Town & Country Planning Act 1990 (as amended)
Town and Country Planning (Development Management Procedure) (England) Order 2015
Approval of details reserved by condition imposed under ref BN/66/19/PL relating to Condition No 3 -
materials and finishes.
Land off Canal Mews Canal Mews Barnham PO22 0DP

Condition Number 3

Arun District Council have decided to **APPROVE details reserved by this condition**

PLOT 1

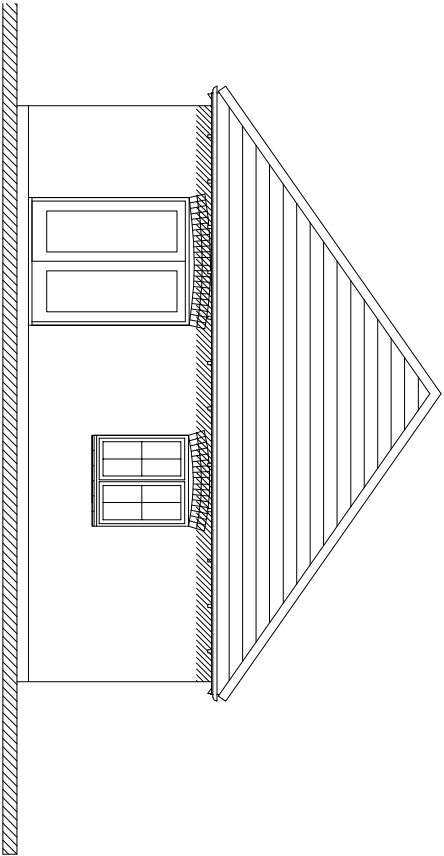
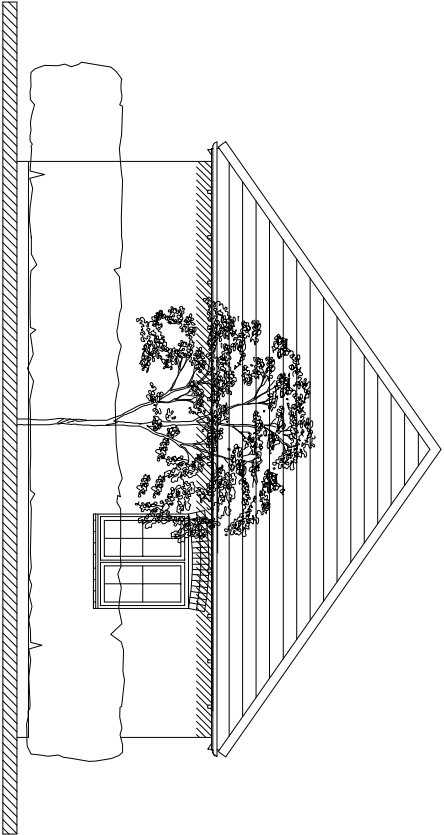
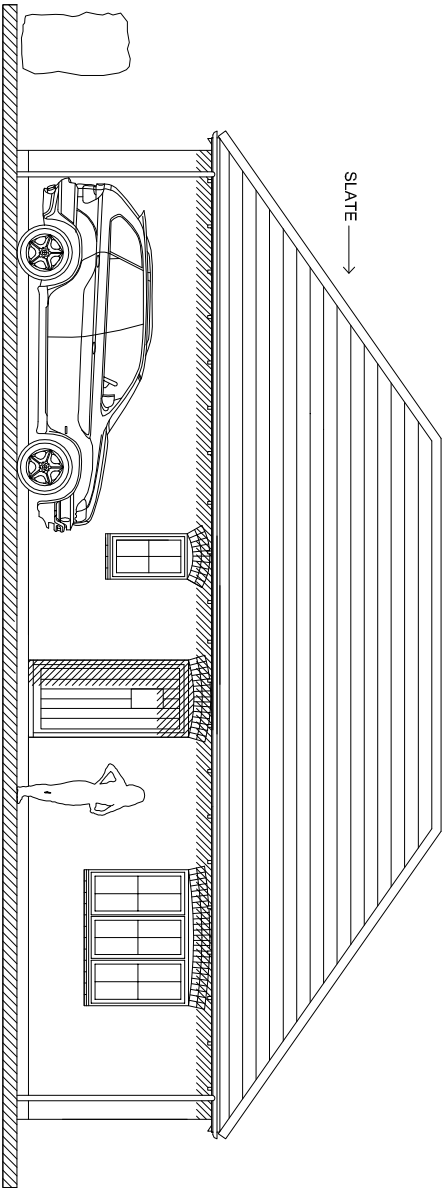
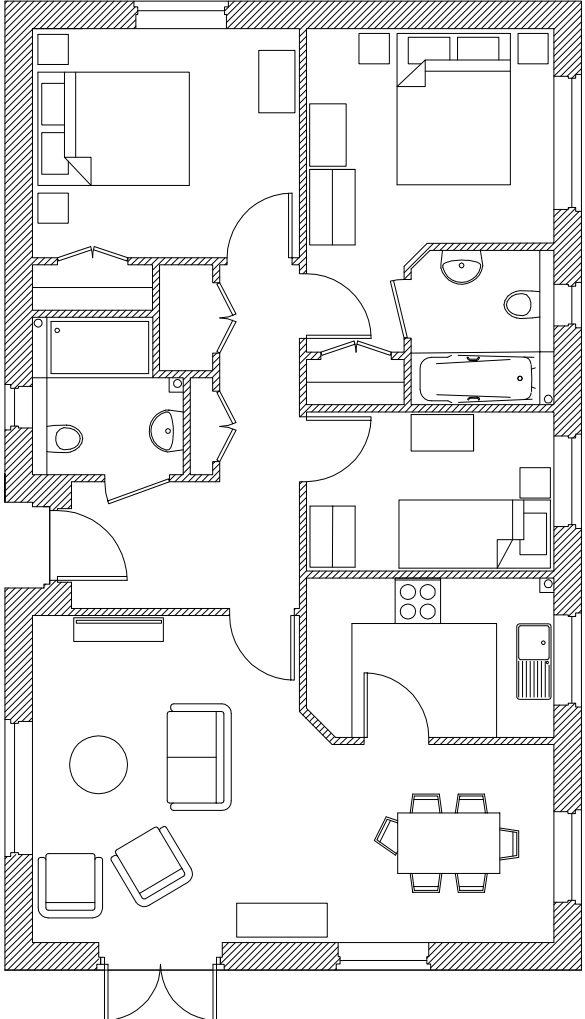
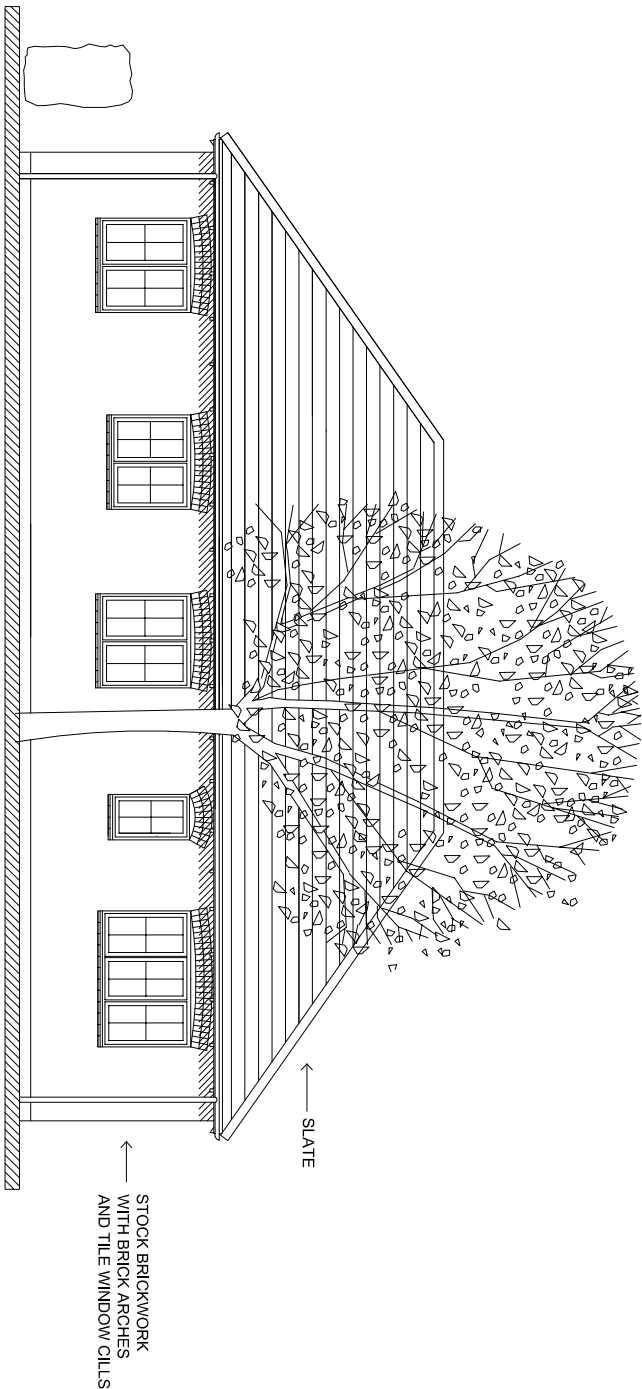
Condition 3 imposed under BN/66/19/PL has been already discharged under reference BN/74/21/DOC, however due to difficulty sourcing the approved roof tile the applicant proposes:

ROOF: Natural Slate Gallegas 37 from SIG roofing. Grey ridge and hip tiles instead of previously approved Redland Rosemary Medium Mixed Brindle Clay Tile with Bonnet hip tiles.

EXTERNAL WALLS: Michelmersh Freshfield Lane 1st Quality Multi with Forterra Atherstone Red dressing bricks to arches, plinth and projecting string course. Tiled eills remain unchanged.

The details submitted with respect to Plot No 1 & 2: Drawing Nos 1705-13C and 1705-14A, External Material Schedule and 1 image of the roof tile in respect of the external surfaces of the buildings (roofs)

dated 22/11/21 are considered to be satisfactory having regard to the character & appearance of this location and to be similar to materials of the existing dwellings.

Therefore, the condition is fully discharged insofar as the submission of details relates and on the understanding that the scheme will be implemented in accordance with the approved details.
